**Section 96A of the Town & Country Planning Act 1990 (as amended)
Town and Country Planning (Development Management Procedure) (England) Order 2015 (as amended) -
Article 10**

Application No: EP/132/21/NMA
Site Address: 27A Sea Lane East Preston BN16 1NH
Description of works: Non-material amendment following grant of EP/2/21/HH for the alteration of front balcony and rear Juliet balcony doors from being single doors with windows either side, to double doors.

Elevations (1:100)

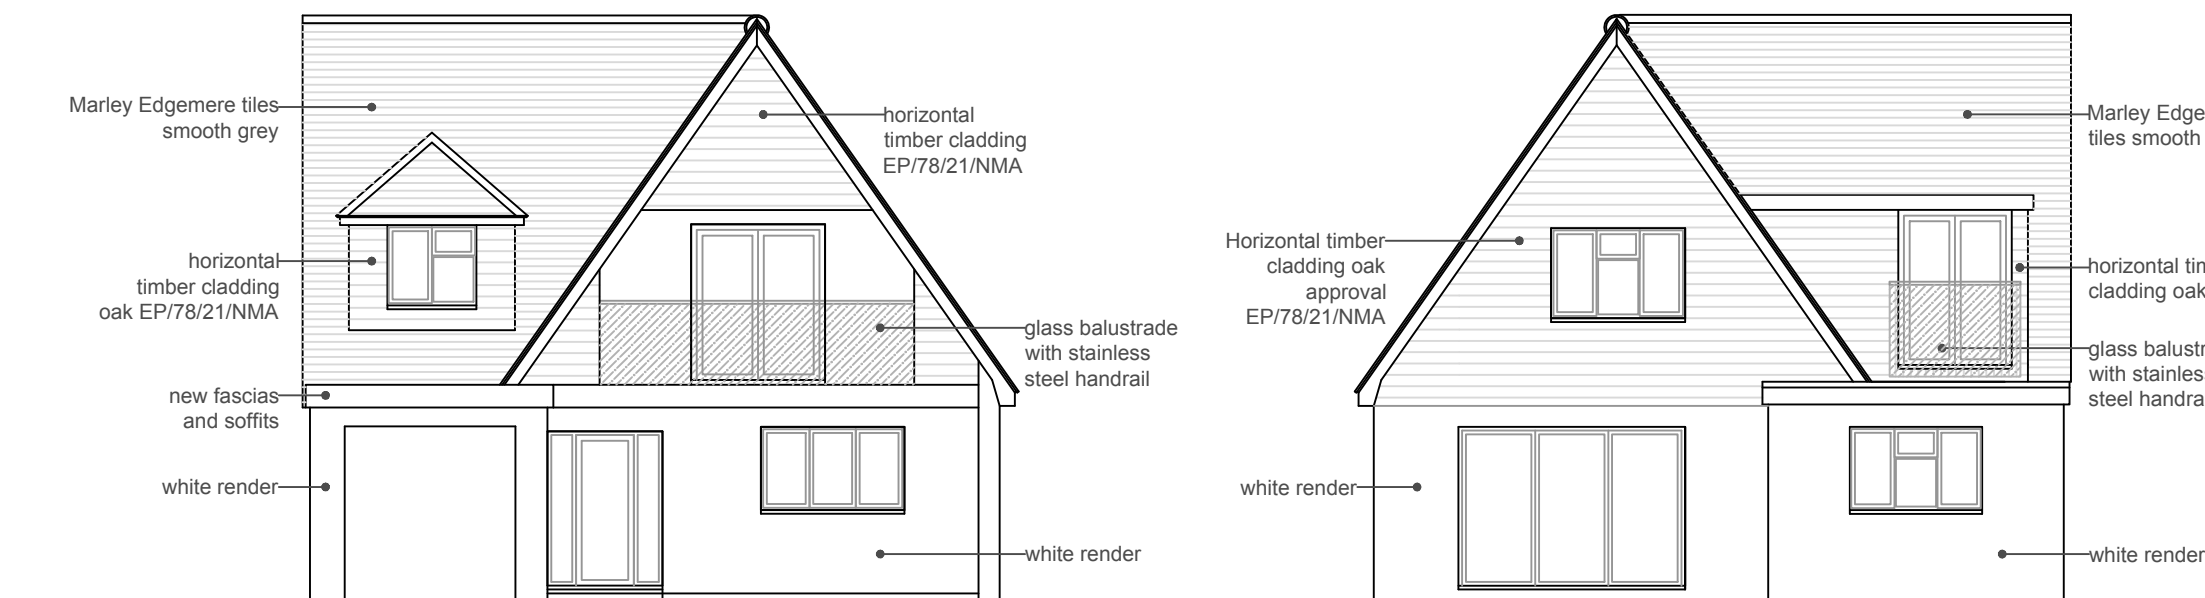
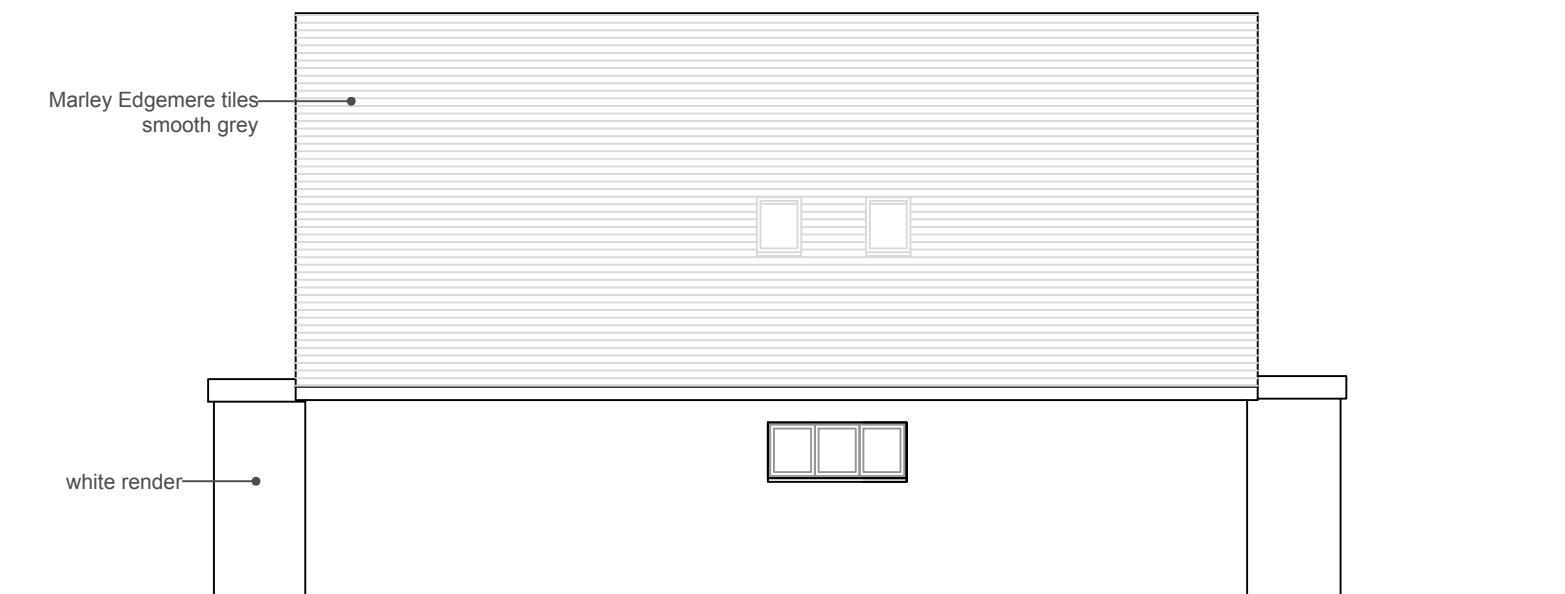
I am writing to object to the non material amendment application put forward from 27a Sea Lane East Preston on 15/10/21. I fully endorse all of the points of objection submitted to you from Mr And Mrs McNamara. I too am worried that due to potential further non material amendment applications, the original planning refusal will eventually be overturned. The single door and Juliet balcony were approved, but the proposed double doors would give a much wider open viewpoint over neighbouring properties, which was the main point of objection originally.

The double doors are already in situ before the amendment is even considered, which surely cannot be right.
